Application No: BE/59/21/PL
Site Address: 339 Chichester Road Bersted PO21 5AN
Description of works: Replacement of blockwork boundary wall with fence and new vehicular access (resubmission of BE/149/21/PL).

Thank you for your internet representation made on 2nd June 2021 which has been recorded as an objection with the comments as follows:

SITE PLAN - SHOWING VISIBILITY SPLAYS
1:500 SCALE (at A3)

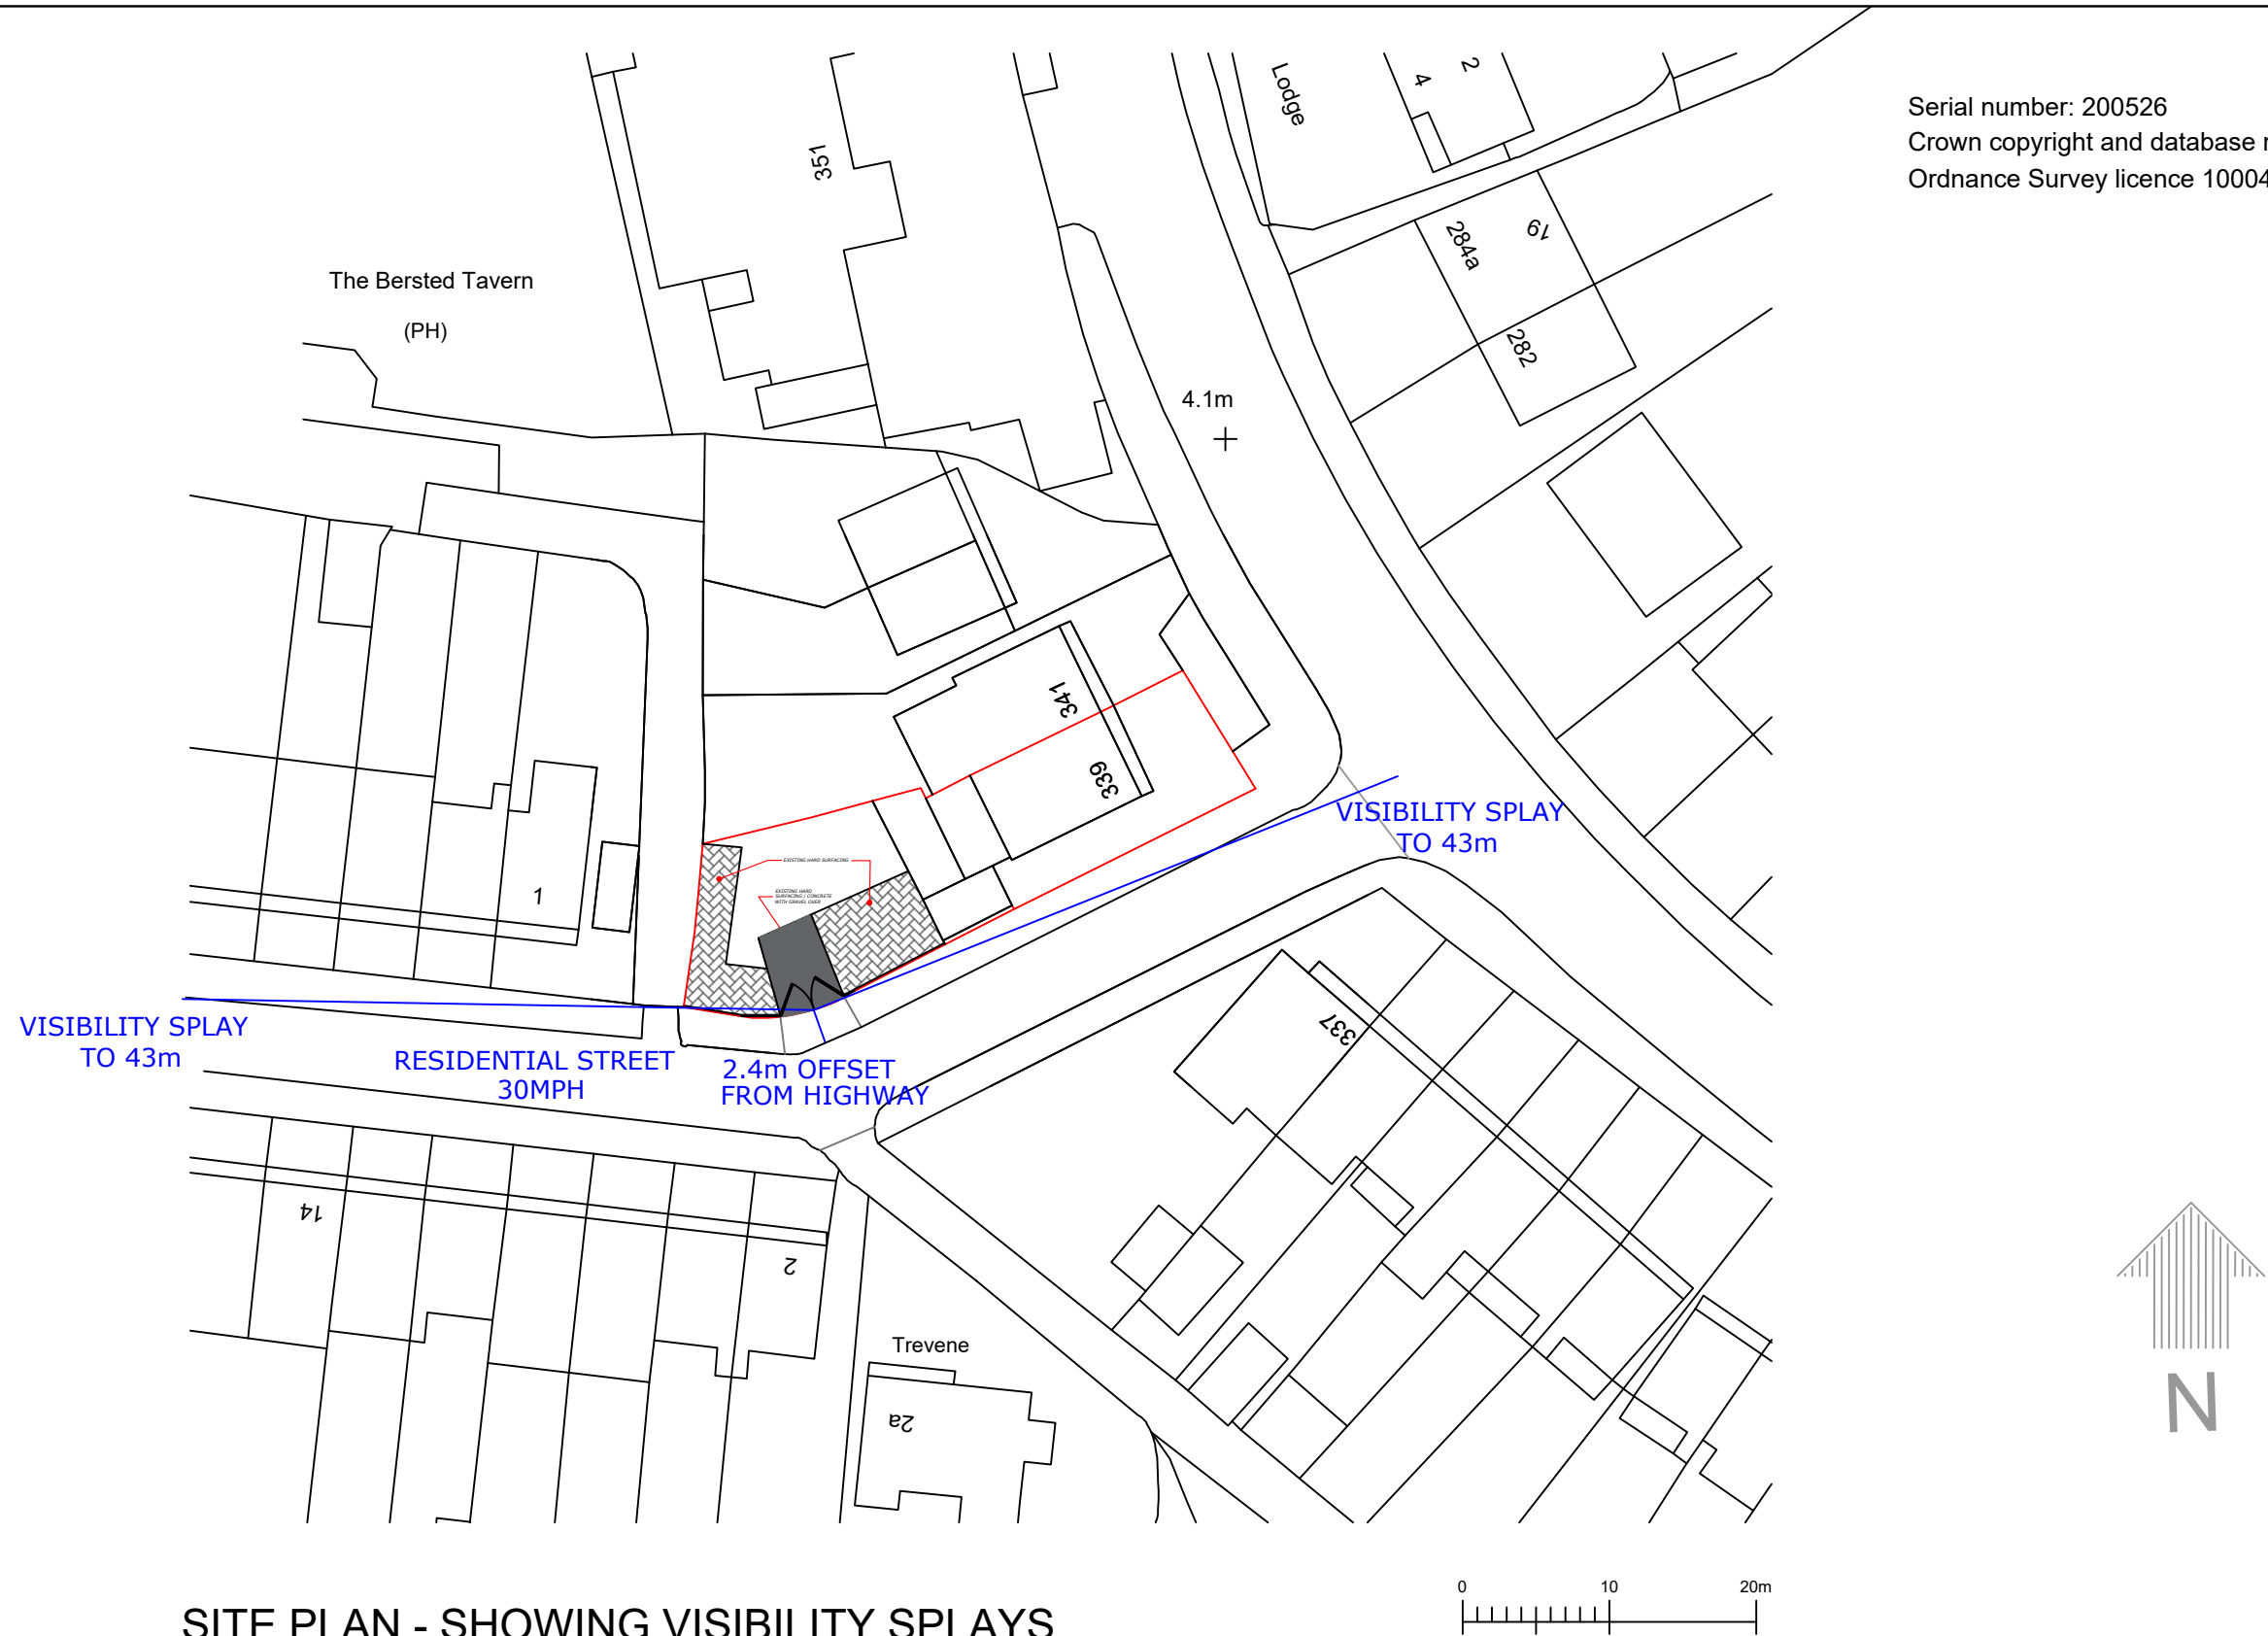
In response to the WSCC Highways consultation what they have advised is utter nonsense and disregards any common sense toward the safety of the public in favour of an Applicant whos only concern is making financial gain in the future. Visibility was not shown on the plans which showed the Vehicular Crossing in the wrong place. As this was advised using those plans which gave a more favourable visibility distance this advisory is flawed.

WE demonstrated to the Bersted Parish Council exactly how little visibility is available and it is no where near the required distance of 43 mtrs.

No provision has been made in the plans regarding turning or space to park more than one car. In his Application he is applying for 1 space. He has 4 spaces at the front of the property already.

He also hasn't included any information about extending the 3m of concrete hard standing he currently has nor mentioned the current hard standing is to small and impermeable.
